**Harnett County**  
108 EAST FRONT STREET  
LILLINGTON, NC 27546  
Phone:  
Fax:

11/17/2020

SUBJECT: **SFD2001-0057**  
**SINGLE FAMILY DWELLING**

Here are the results of all Inspections located at **825 COACHMAN WAY:**

**CRAWL LAYOUT**  
DRAWING SCALE : NTS

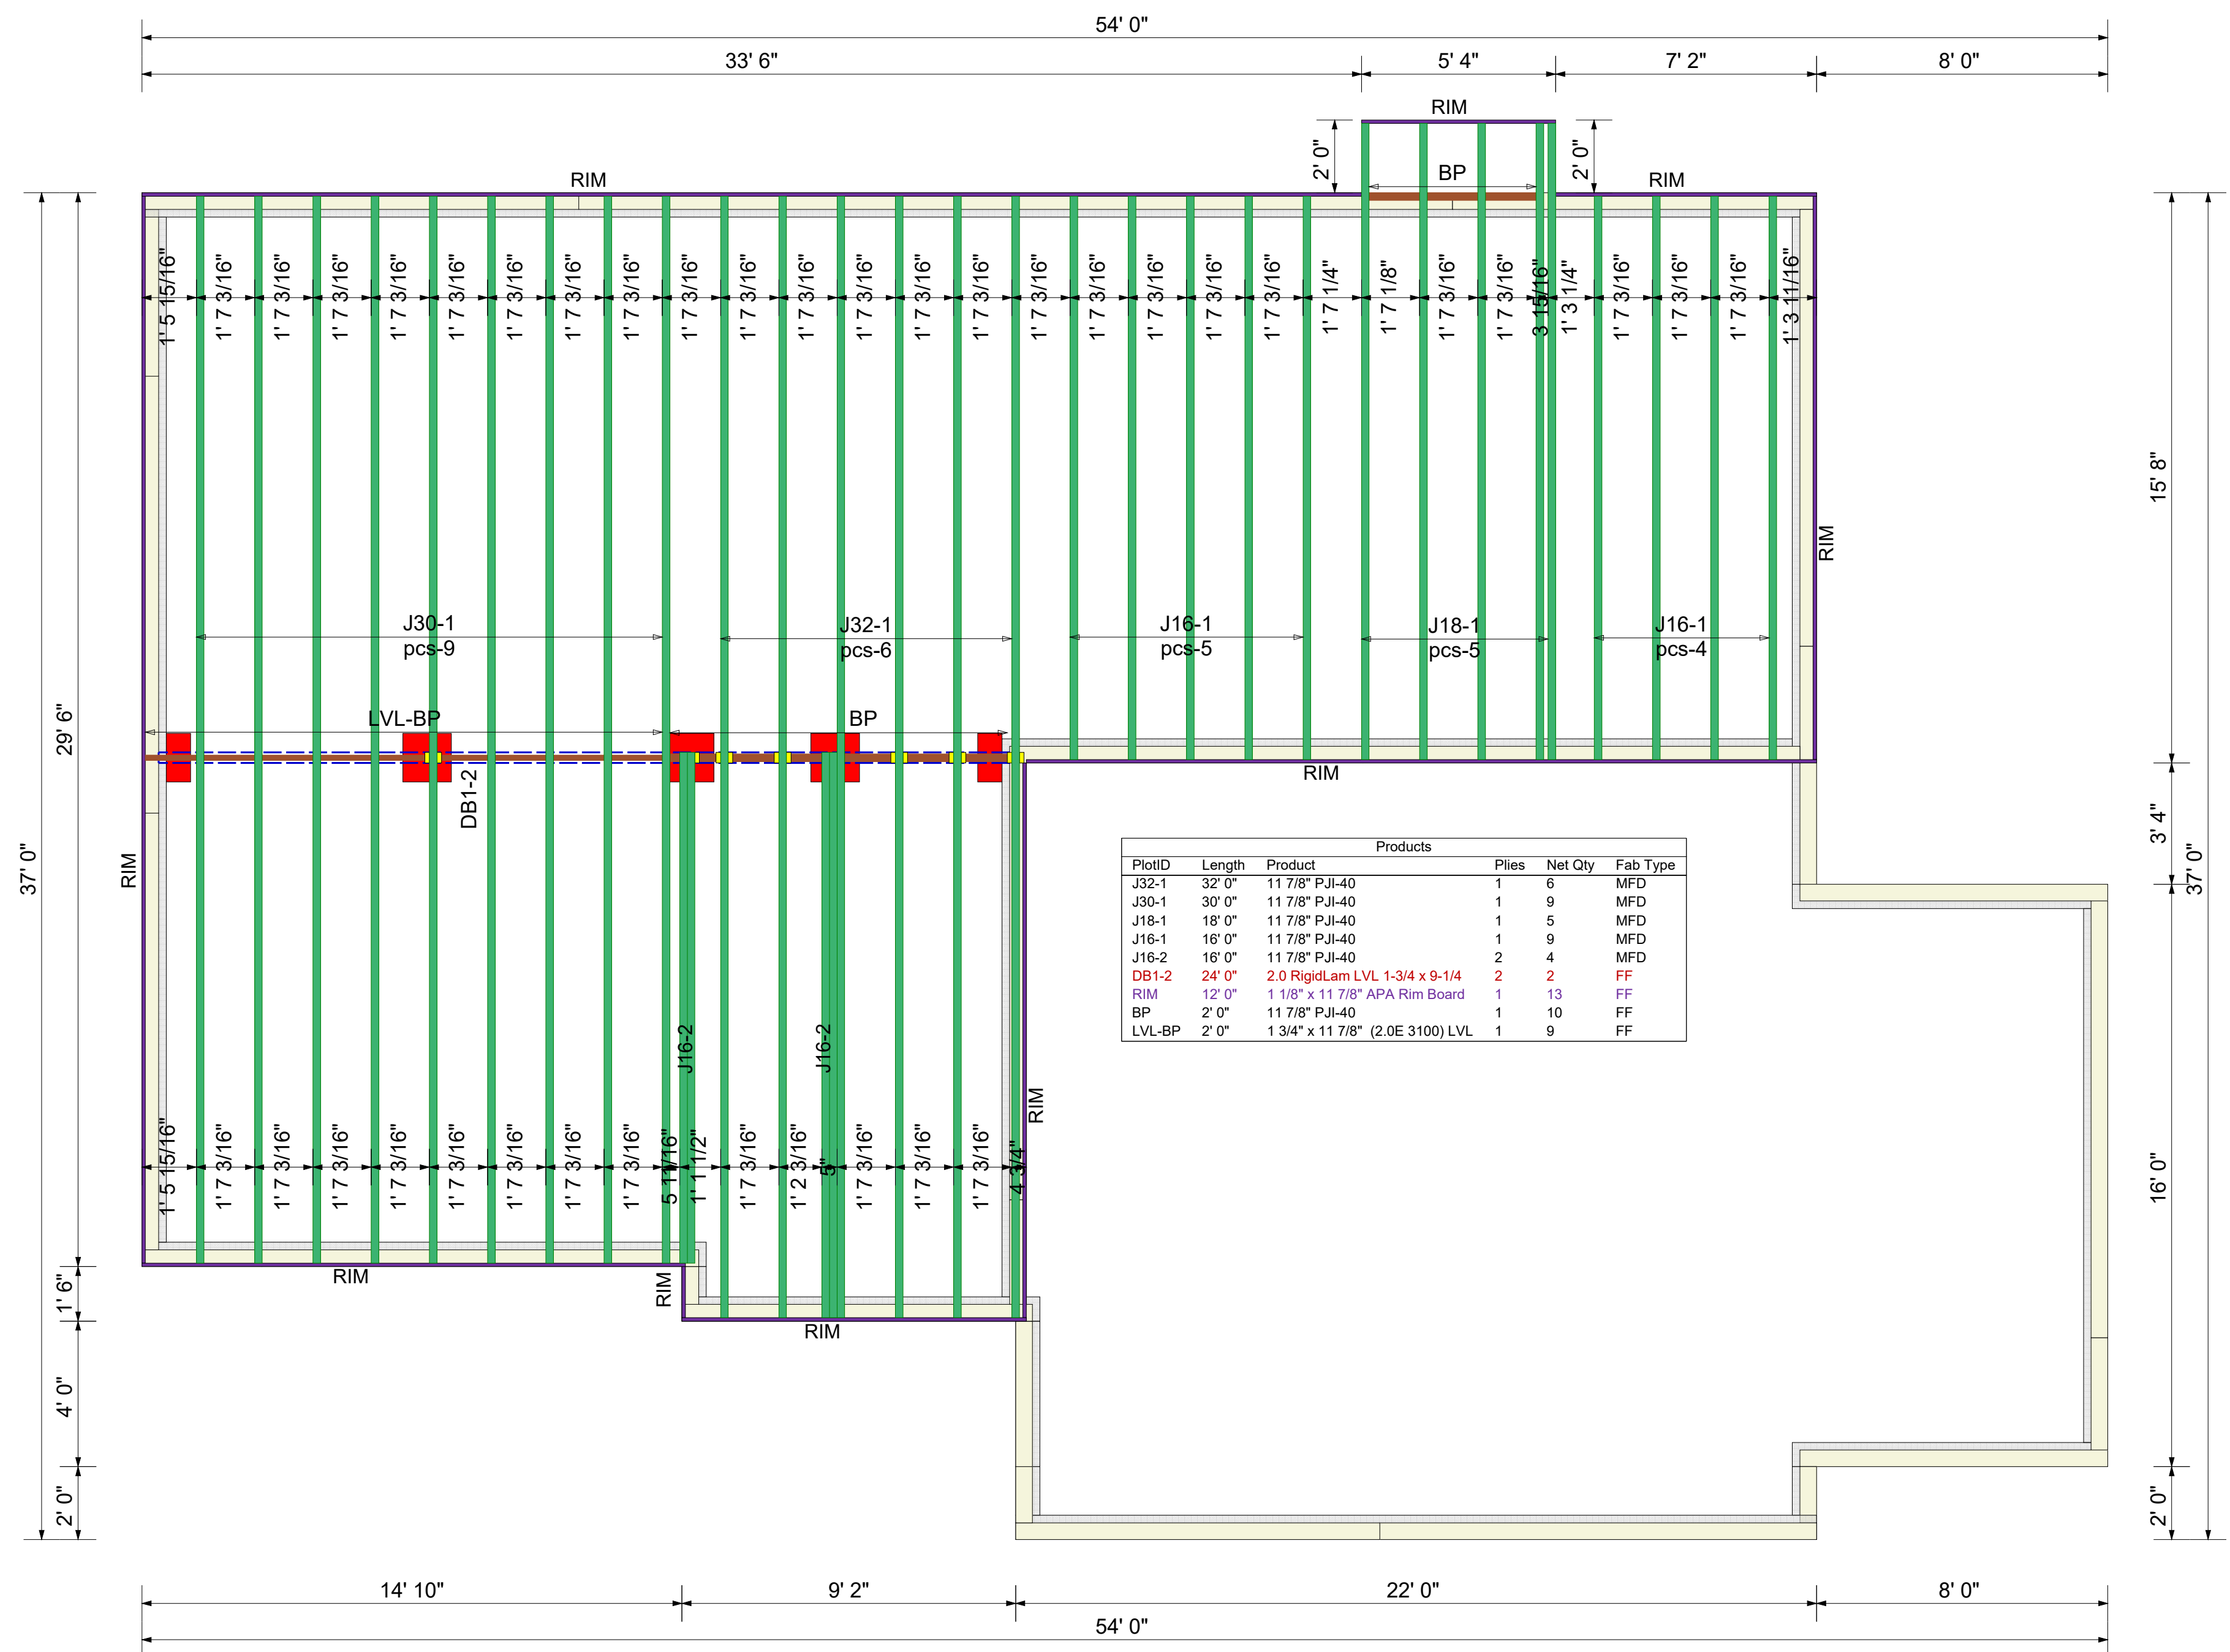
Inspection Type: OPEN FLOOR  
Scheduled Date/Time: 7/1/2020  
Completed Date/Time: 7/1/2020  
Inspector: Steven Gazlay  
Result: DISAPPROVED  
Remarks:  
Notes: Inspector SBL changed the inspection assignment from SBL to SPG  
Provide paperwork an tgi layout and information.
